Application No: LU/217/20/HH
Site Address: 34 Pier Road Littlehampton BN17 5LW
Description of works: Rear extension & outbuilding.

Thank you for your internet representation made on 1st September 2020 which has been recorded as an objection with the comments as follows:

Proposed Elevations

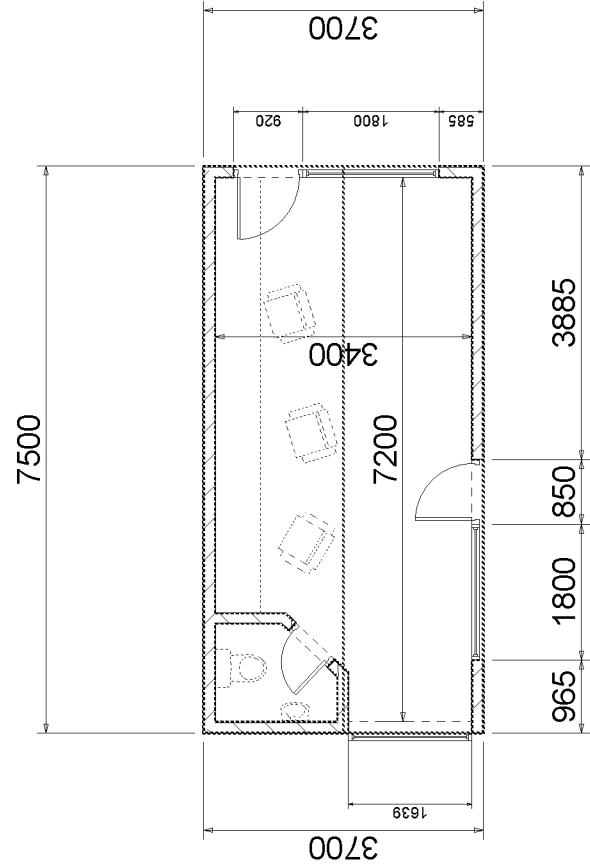
Having reviewed the plans I must object to the height of the extension chimney. The chimney will exhaust the smoke approx at first floor level and thus the output has potential of drifting directly into my property windows at first floor. Looking across the internet it is clear that chimneys must be minimum 4.5m above the fireplace, however the other factors of wind eddies and local contamination comes into effect. On these grounds I must object to this low level chimney on grounds of possible smoke contamination within my property close by
